13 Millingandi Road, Millingandi

10 Lot Rural Residential Subdivision

Preferred Project Report

Major Project 06-0032

Appendix 8.3

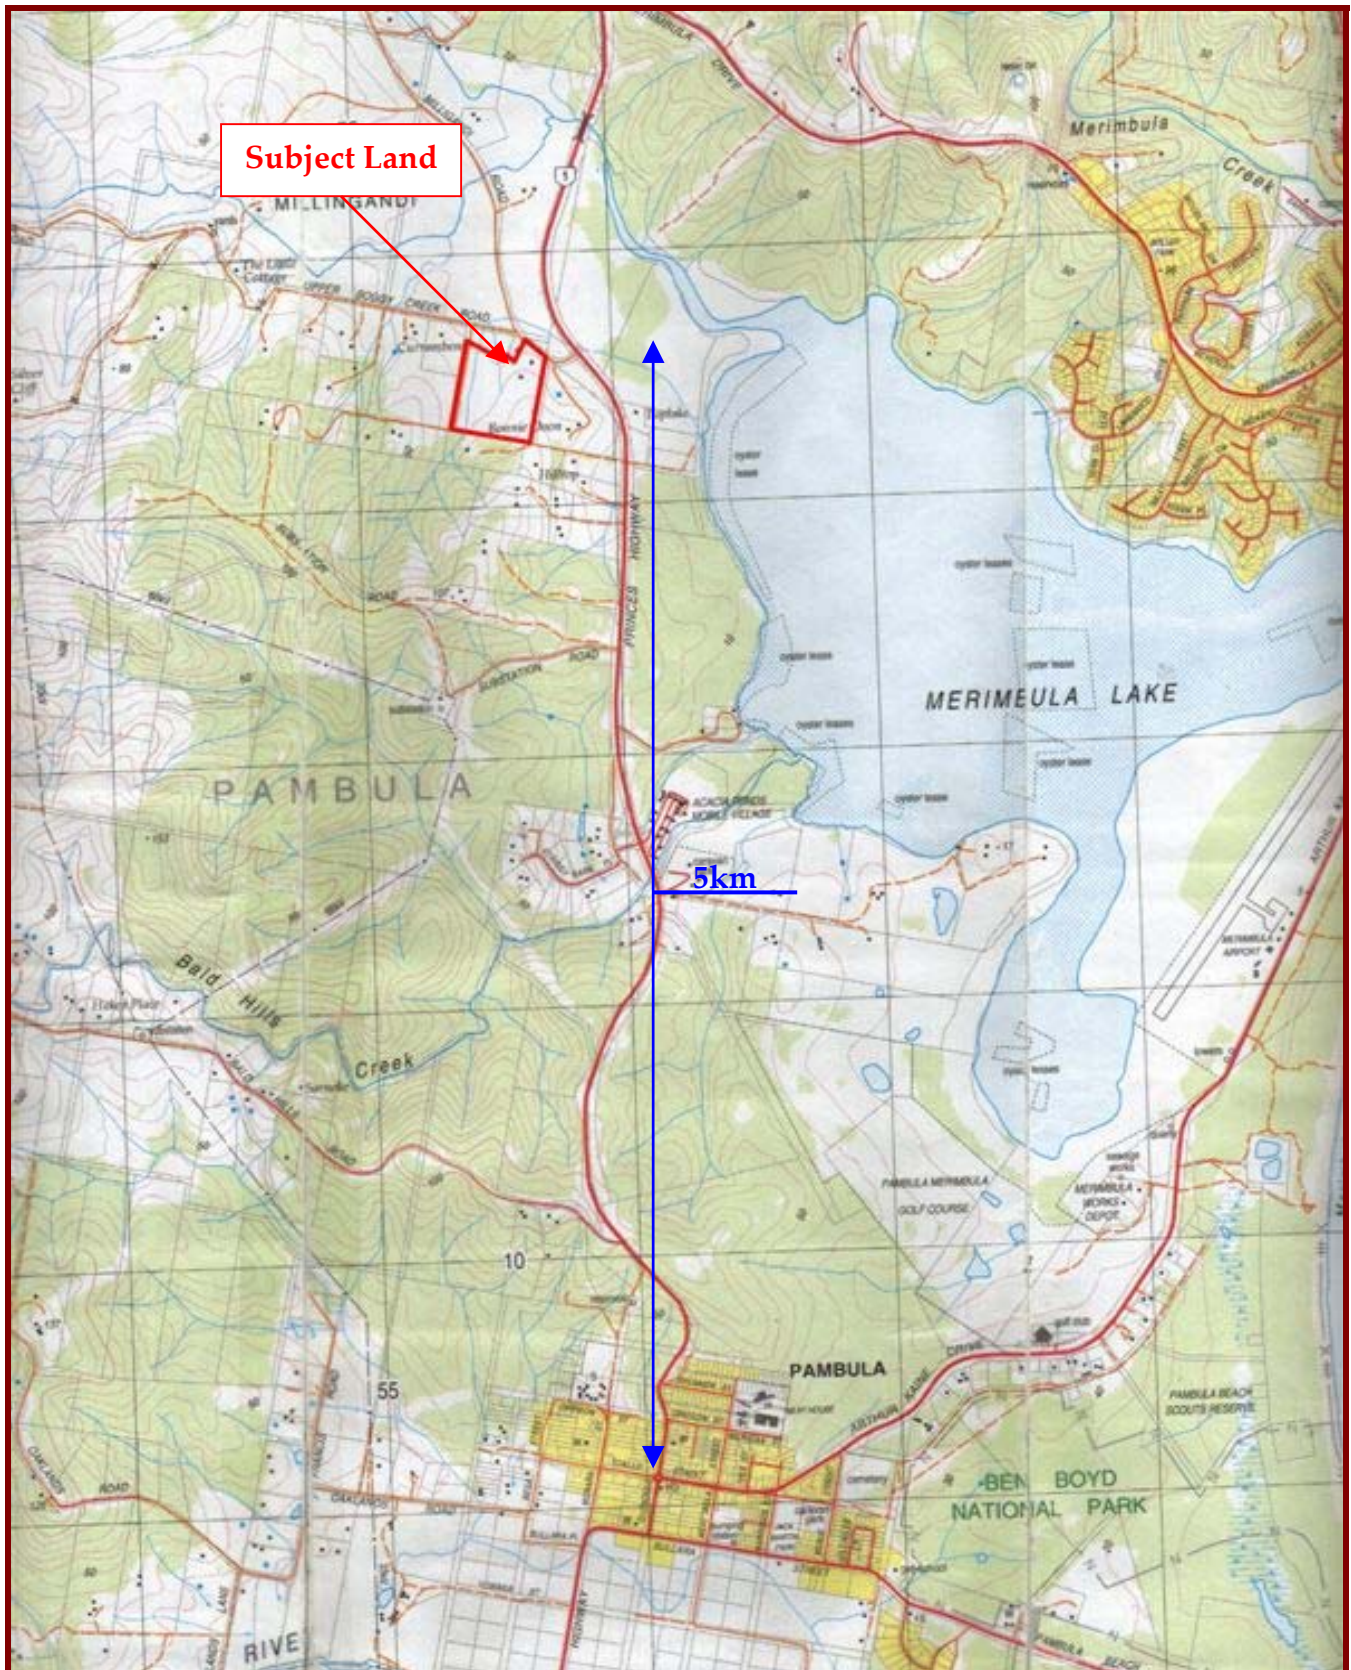
The currently proposed right-of-carriageway, along the western boundary of the site, will service more than four properties. This is inconsistent with the requirements of clause 11 of Council's DCP No.2 (Subdivision Standards) which allows for only a maximum of four lots to be serviced by a right-of carriageway. It is recommended the proposed road layout is redesigned to conform with Council's standards. Please refer to Council's comments on the required road redesigns (letter dated 3 September 2009).

As such, you are requested to make appropriate amendments to the proposed building envelopes designated on the subdivision plan to ensure suitable setbacks are achieved.

Two potential sites for dams are indicated on the subdivision plan (provided in Appendix 8). Demonstrate that the proposed dams confirm with the 'maximum harvestable right dam capacity' as stipulated by NSW Office of Water 'Farm Dams Assessment Guide'.

A re-design of the access standards and locations has been undertaken and now complies with the requirements of Bega Valley Development Control Plan 2.

A public road, to be dedicated to Council, has now been included servicing Lots 1, 5, 6 & 7. From the southern end of this Public Road, a Right of Access will be created servicing Lot 4. An easement 20m wide and 50m long will be constructed to a standard of a 3.0m wide sealed carriageway with 0.5m sealed shoulders. From here a 2nd easement will be created at a width of 15m and length of 60m, with a construction standard of 3.0m seal with 0.5 gravel shoulders.

As such, we confirm that each and every lot now achieves the required 20m setbacks from all boundaries and Public Roads and is shown on the amended proposal plan, attached (Appendix 1).

In regards to the concerns raised regarding proposed Dams and harvestable rights, we now advise the proposed dams have been removed from the plan. In addition to this and in accordance with the Water Cycle Management Study, the existing dam on Lot 4 will also be removed to comply with necessary setbacks for OSM purposes. This will be undertaken at the time of road construction however it will remain for the interim to service the existing rural operations of the land.

APPENDIX 8.9

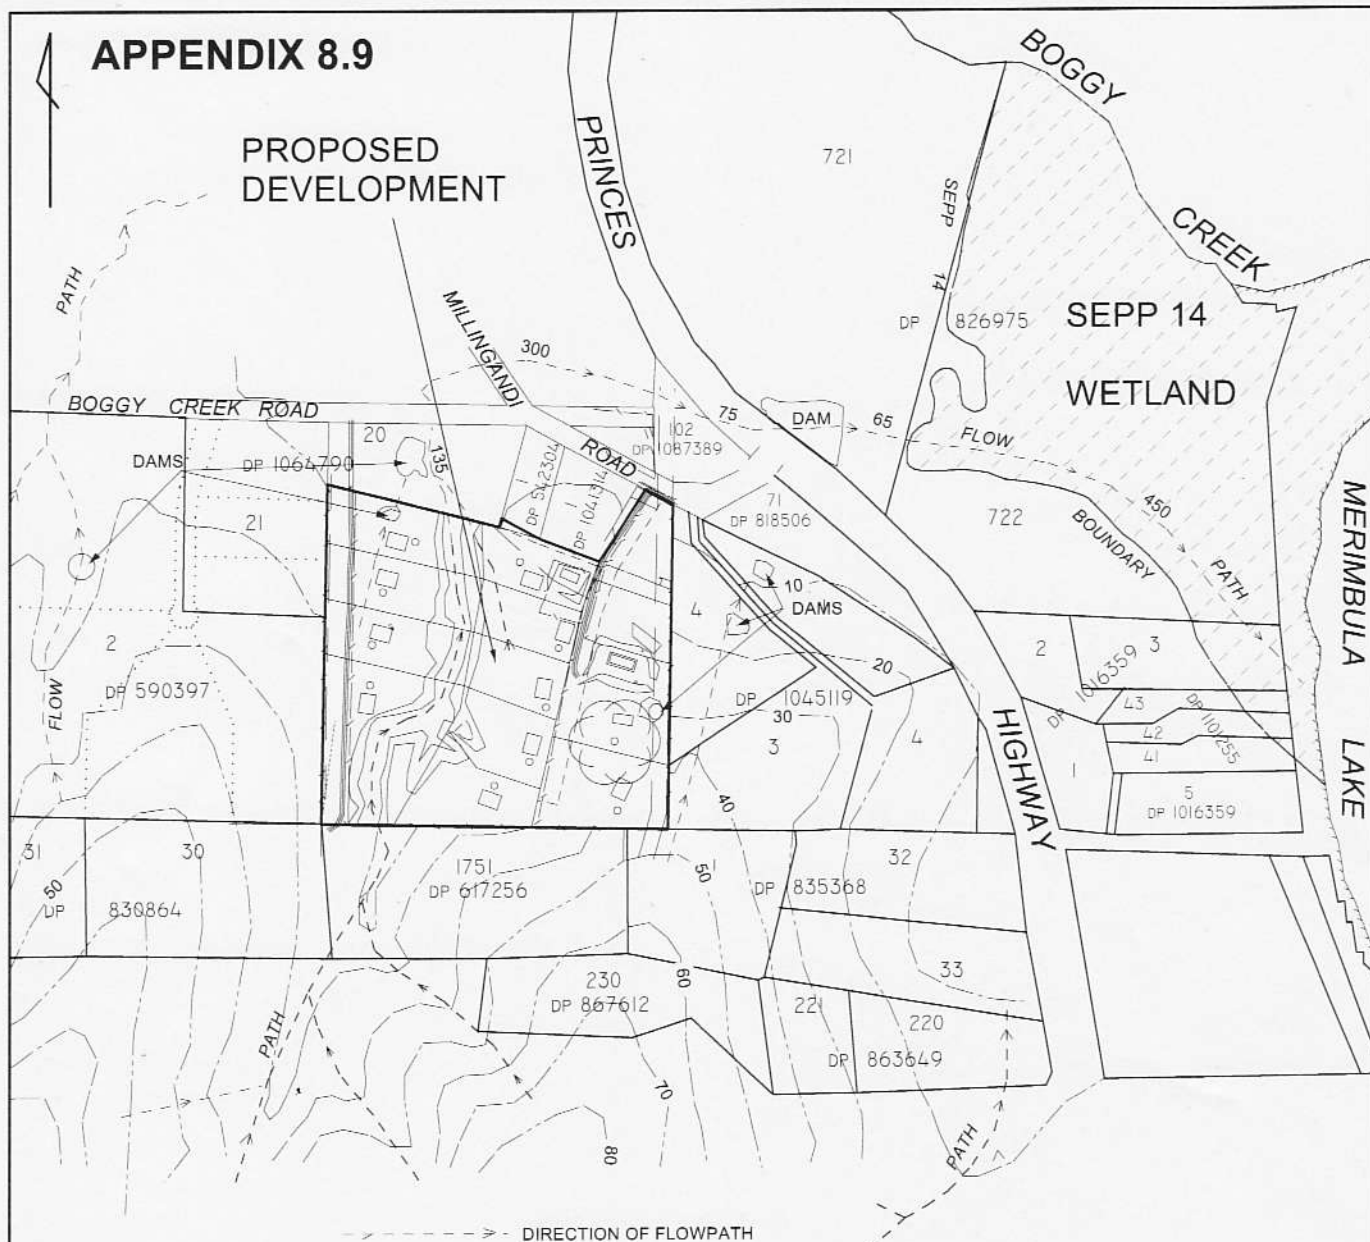
- Insufficient water quality modelling (using appropriate best practice tools, such as MUSIC (Model for Urban Stormwater Improvement Conceptualisation)) has been undertaken to demonstrate the stormwater flows from the development will not contain increased nutrient loads (such as Total Phosphorus, Total Nitrogen and Total Suspended Solids) and impact on downstream wetlands and Merimbula Lake.
- Section 2.1.7 of the EA indicates that a range of water sensitive management strategies will be utilised in the development including: rainwater tanks, bioretention rain gardens and bioretention swales. However, these features have not been included on a Stormwater Concept Plan and have not been incorporated in relevant water quality modelling.

- Demonstrates the post development peak flow rates (as measured in m³/s) from the site to downstream receiving waters are similar to existing peak flow rates so that existing hydrological conditions are maintained.
- Demonstrates treated runoff generated by potential development will provide suitable pollutant load reductions. MUSIC (or best practice water quality modelling programs) should be used to model pre and post development water quality in runoff to support this outcome.
- Outlines the proposed locations of various 'water sensitive urban design' measures to be proposed on the subdivision.
- Preparation of an appropriate stormwater concept plan. The total catchment area should also be indicated on the plan.

To address the concerns outlined above, we have engaged the services of external consultants, SEEC Morse McVey, to undertake the preparation of a detailed Water Cycle Management Study.

We are confident that the subsequent report sufficiently addresses all the issues raised and attach the study as Appendix 2 of this report.
